PROJECT: Land to the south of Barnham Station

TN01: Response to consultee comments (BN/142/20/OUT)

Planning Application Ref: BN/142/20/OUT

Location: Land south of Barnham Station, Barnham

1311.03

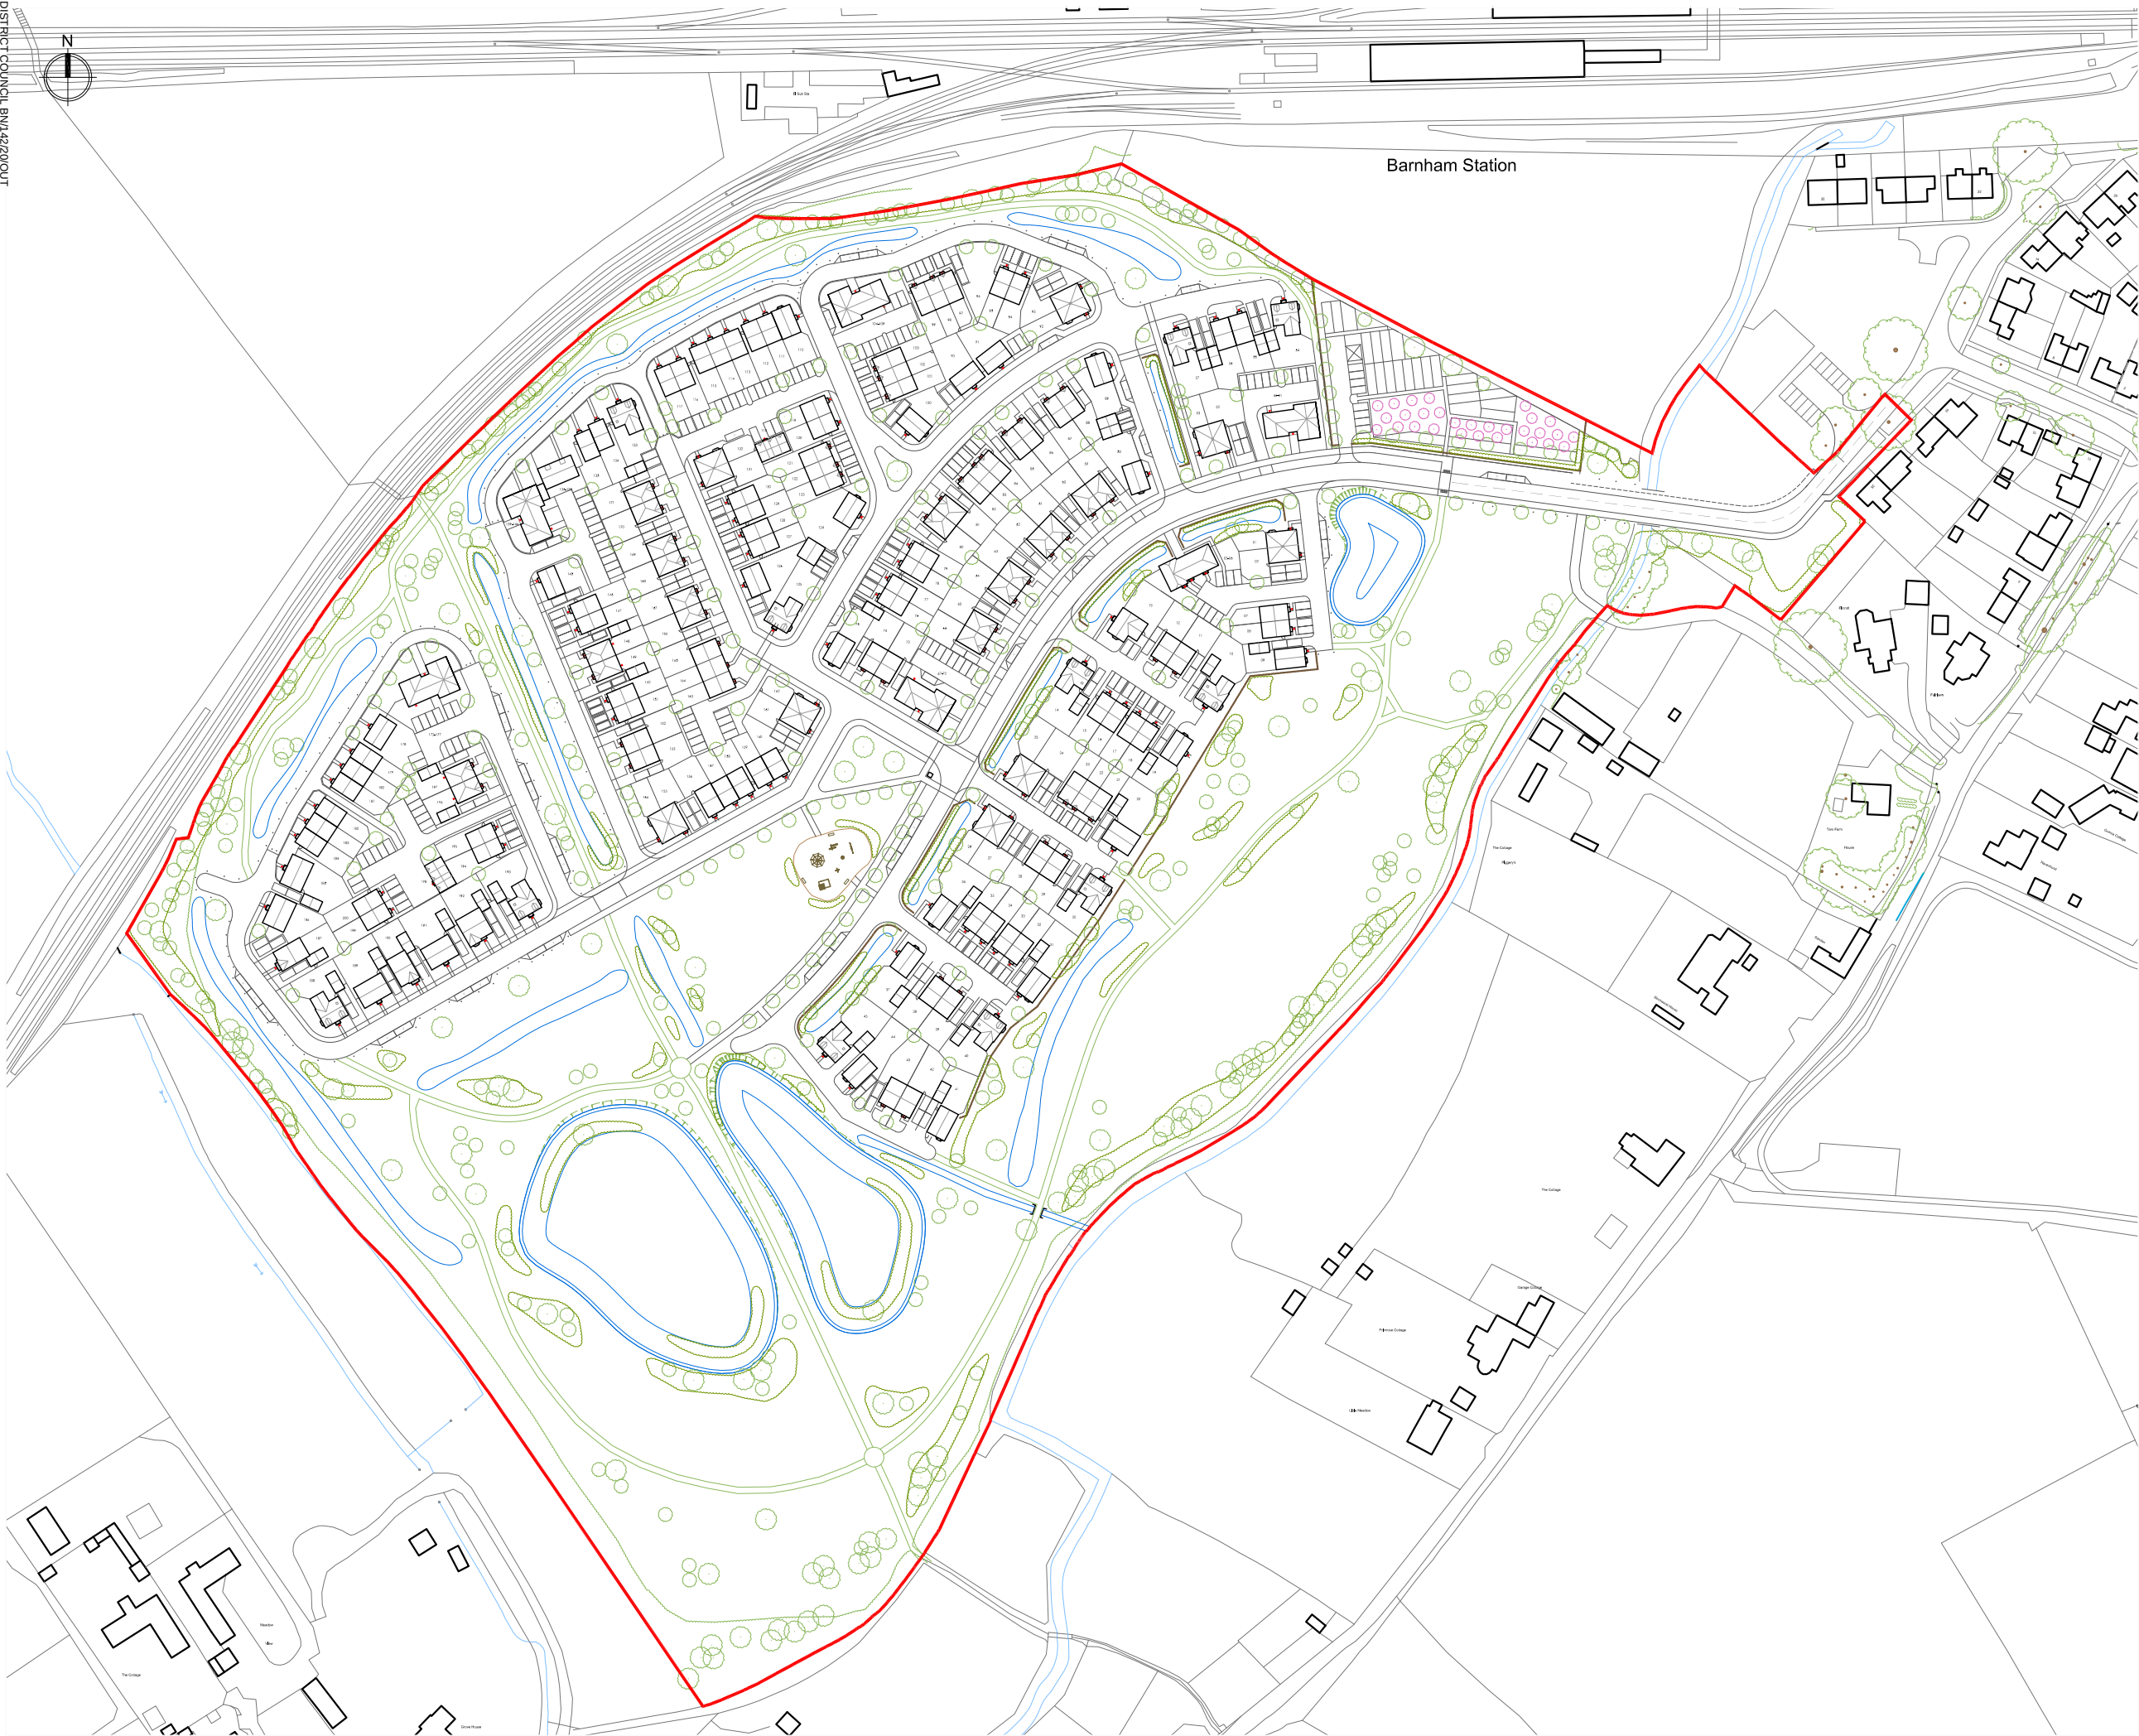
- In respect of Illustrative Site Layout Plan, dwg. ref. 1311.03., I make the following specific comments:
 - I defer to our Landscape and Leisure Officer in respect of how the site relates to the wider strategic housing allocation (SD5 - BEW) and ensuring green/blue infrastructure connectivity, enhancement of wildlife corridors and subsequent planting proposals – although am encouraged by the open space/above ground Suds features around the site and their relationship to higher value trees and hedgerow.

- I see no obvious problem with the proposed location of dwellings and the majority of associated infrastructure.
 - I am concerned about the approach to the site's main access, specifically in the absence of dwg. no. ITB14160-GA-010 which describes the highway improvements proposed for Marshall Close (as referenced within submitted plan from i-Transport, dwg. no. ITB14160-GA-005, Rev C). WSCC Highways Authority in their report of 16th December 2020 state that off-carriageway laybys are proposed to assimilate the existing on-road parking and thus allow adequate space for passing vehicles. A large, mature tree (T43 beech - Category A) of high public amenity value with correspondingly large nominal *root protection area* (RPA) looks vulnerable at this stage, in the absence of a scheme showing provision of laybys outside of both the crown spread and RPA.

- Furthermore, I would like to be reassured that the mature tree (T49 beech - Category A), similarly of high public amenity value (also outside of the site boundary shown red, yet possibly within the application area) growing on island verge at the junction of Church Lane and Yapton Road, will not be affected by any enhancement of the public highway deemed necessary to meet the additional traffic demands associated with this development proposal.

- II. Perceived risk to T49 Beech; linked with potential to be affected by enhancement of the public highway at the Church Lane-Yapton Road junction.
- 1.3. As a consequence of these concerns, Aspect Arboriculture and the applicant's transport consultant i-Transport, have undertaken a joint review, revealing that there are no proposed amendments to the highway and extant verges that might affect either of the Beech trees. This conclusion has been accepted in writing by the council's Tree Officer³.

- 1.4. The review cited at 1.3 disclosed a previously unknown conflict between layby proposals and two comparatively lower quality trees on Marshall Close, necessitating the removal of both trees⁴. This fresh matter was introduced in writing to the Tree Officer on the 29th January, including plan extracts to illustrate the conflict⁵.

- 1.5. The principle of removing both trees has been accepted by the council's Tree Officer in writing, subject to acceptable mitigation and caveats i.e.: 'I hold no strong view on the removal of the highway trees T36 & T38, as if any tree removal needs to be made to satisfy wider highway requirements, then their loss should be tolerable with adequate mitigation in place. Any endorsement of that proposal and requirement for compensatory planting elsewhere would have to be given/considered by both WSCC (as highway authority) and our planning department during the usual processes of application³.
